From: Michael Eastham <Michael.Eastham@arun.gov.uk>
Sent: 27 October 2020 11:29
To: Planning.Responses <Planning.Responses@arun.gov.uk>
Subject: FW: FW: BN/84/20/PL - Angels Nursery

Please upload onto Ocella the email below which is a further consultation response from **ADC Drainage Engineers** to Section 73 application **BN/84/20/PL** relating to Angels Nursery, Yapton Road, Barnham.

From: Laura Gibbons [REDACTED]
Sent: 27 October 2020 11:05
To: Michael Eastham <Michael.Eastham@arun.gov.uk>
Subject: Re: FW: BN/84/20/PL - Angels Nursery POS

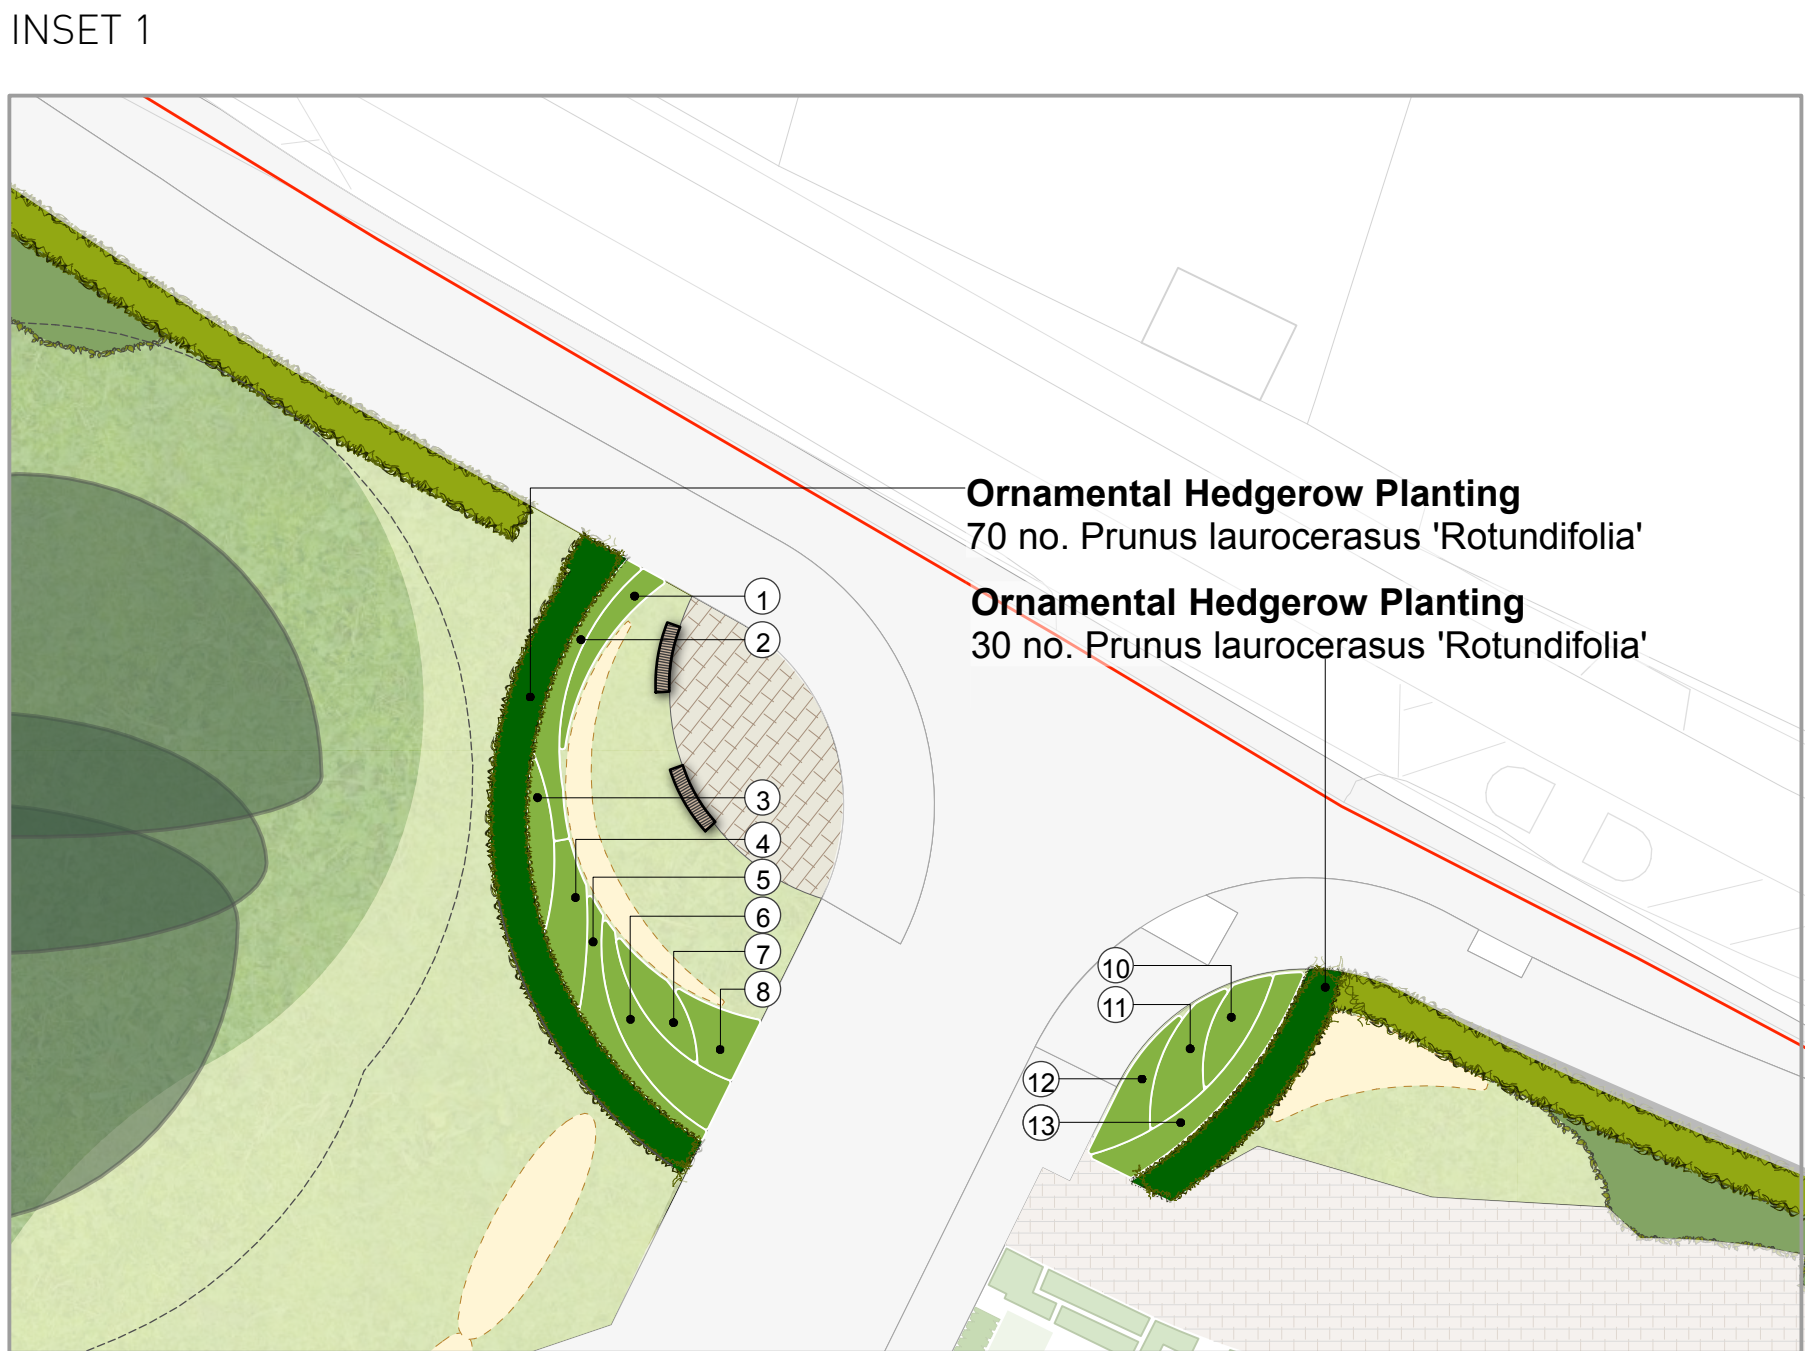
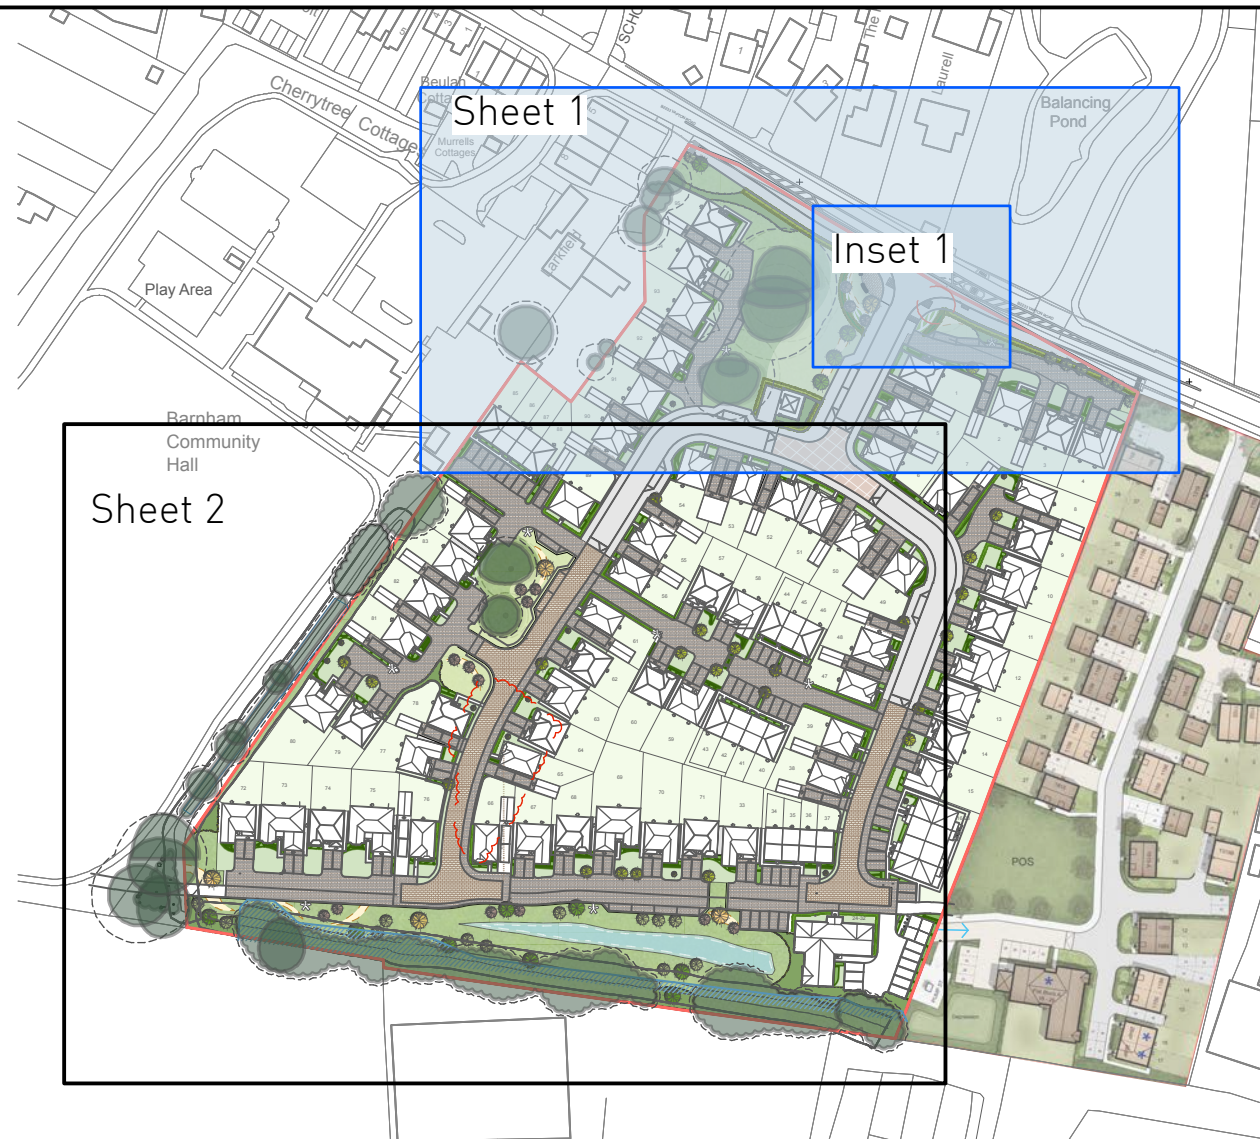
Sorry that it has taken me some time to look over this. I have one remaining concern regarding the application and that is the conflict between landscaping proposals and drainage proposals. There appear to be numerous trees proposed within or directly adjacent to the attenuation basin. It is essential that tree roots are kept away from the attenuation basin as they will likely damage the liner and significantly impact upon the functionality of the basin, as groundwater would be able to ingress. This could ultimately result in the basin having insufficient space for surface water, and result in an increase in flood risk both on and offsite.

Therefore, our holding objection remains at this time. To overcome this the applicant should submit a revised landscape plan and a drawing that shows root potential areas and their interaction with the proposed drainage features.
